Re: San Roque & La Serena
441 & 457 Coors Blvd. NW
Traffic Circulation Layout
Engineer's Stamp 09-25-23 (J10-D049)

Based upon the information provided in your submittal received 09-25-23, the above referenced plan cannot be approved for Building Permit until the following comments are addressed:

**Traffic Circulation Layout**  
**c5.0**

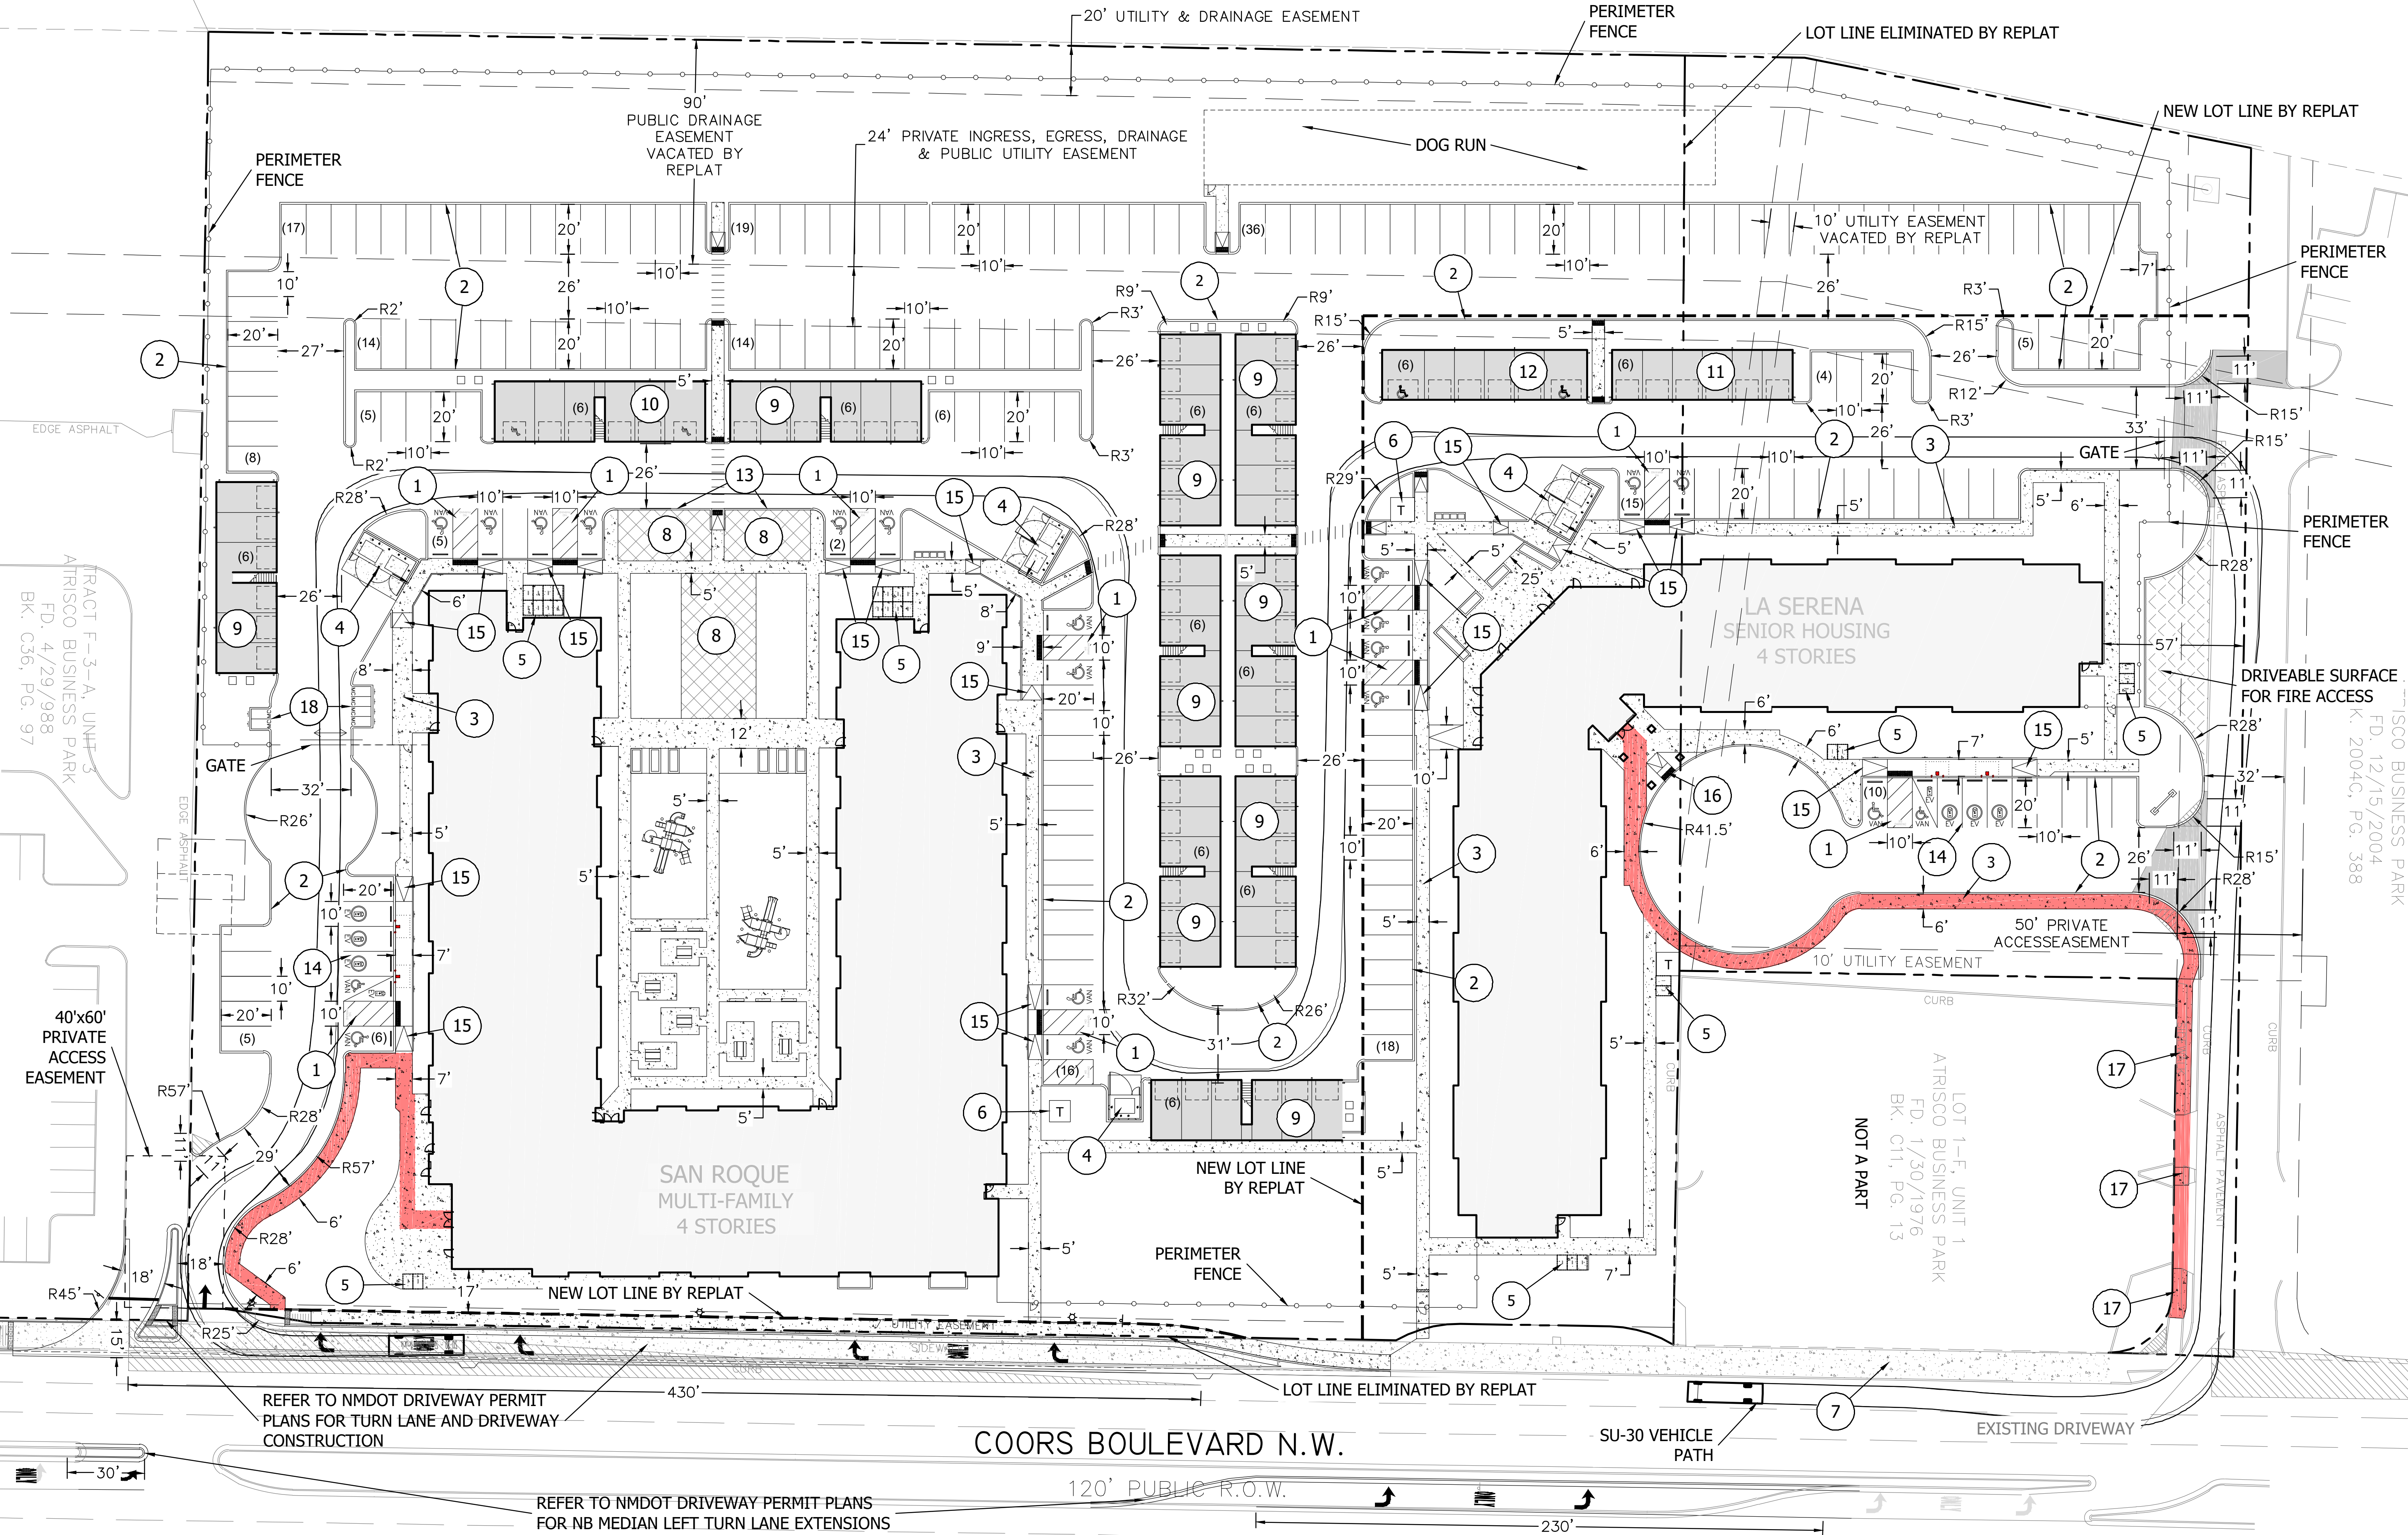
1. NMDOT Approval for the proposed turn lane and driveway access off Coors Blvd. is required prior to approve this TCL.
2. List the number of Motorcycle parking spaces required by the IDO
3. Identify all existing access easements and rights of way width dimensions.
4. Please provide an approved plat showing the shared access easement.
5. Sidewalk must be improved from property line to property line at the north side of the site.
6. Site accesses at the north side of the site must be built per ADA city standard and have Truncated Domes installed.
7. Please show on the site plan this drive aisle width and this ADA rout width.

8. Motorcycle parking spaces shall be designated by its own conspicuously posted upright sign, either free-standing or wall mounted per the zoning code.
9. The pavement marking "MC" should be shown in the opposite direction for motorcycles entering the parking space.

10. Please provide Bike Rack details. Details sheet C7.0 and C7.1 are missing.
11. All bicycle racks shall be designed according to the following guidelines:

15. Per DPM, a 6 ft. wide ADA accessible pedestrian pathway is required from the ADA parking stall access aisles to the building entrances. Please clearly show this pathway and provide details.

16. ADA accessible pedestrian pathway should not be placed behind parking space or adjacent to a vehicular way. Vehicle and pedestrian/wheel chair conflicts should be avoided as much as possible.

17. All sidewalks along streets should be placed at the property line.
18. Refuse vehicle maneuvering shall be contained on-site. The refuse vehicle shall not back into the public right of way.; provide a copy of refuse approval.

19. Provide a copy of Fire Marshal approval.
20. It is not apparent what type of pavement surface is being proposed. A hard driving surface will be required as part of this proposed project for parking area and drive aisles.
